STATE OF NORTH CAROLINA
DEPARTMENT OF TRANSPORTATION

Addendum No. 1

RE: Contract # C204761

2 SECTIONS OF NC-581, AND 21 SECTIONS OF SECONDARY ROADS

REPAIR OF EXISTING PAVEMENT

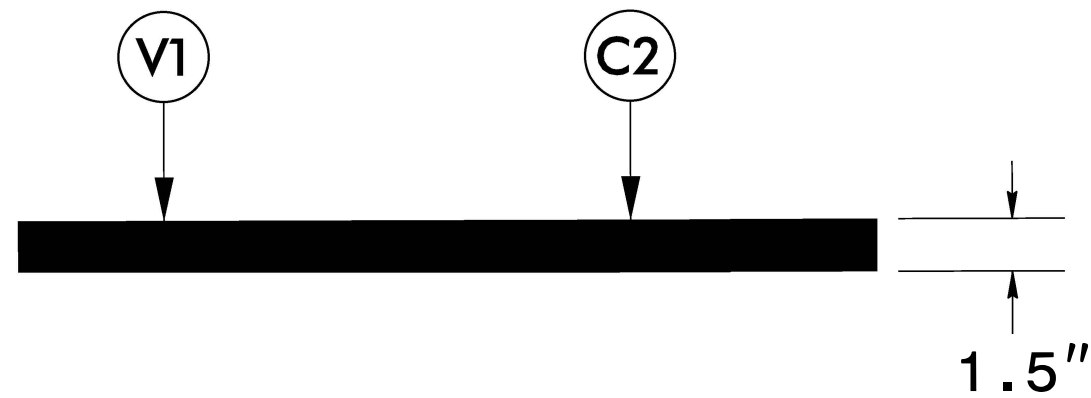
Sheet No.	Revision
9	Sheet revised to reflect work to be performed
16	Summary of Quantities to reflect quantity changes below
17	Summary of Quantities to reflect quantity changes below
